Re: OUFC Planning Application Ref: 24/00539/F

Objection from

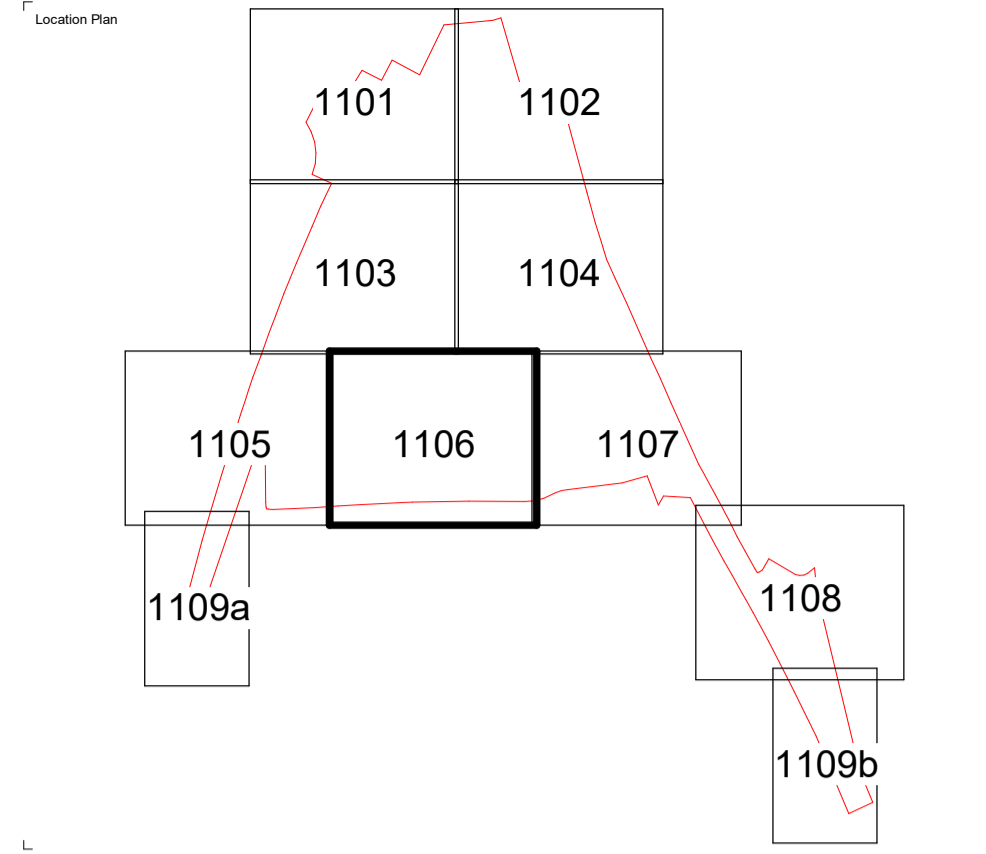
Additionally the proposed ‘**green roof**’ suggested on part of the Stadium is actually according to detailed plans actually be a ‘**brown roof**’ where a surface will be provided for plants with windblown seeds to naturally colonise. Such a dry roof plant assemblage will not compensate for loss of the rich wetland plant assemblage currently in the Triangle centre. I can’t see any plants that are not stonecrops on a dry roof surviving 40 °C summers coming soon. Nor will a green wall compensate for loss of wet grassland plants.
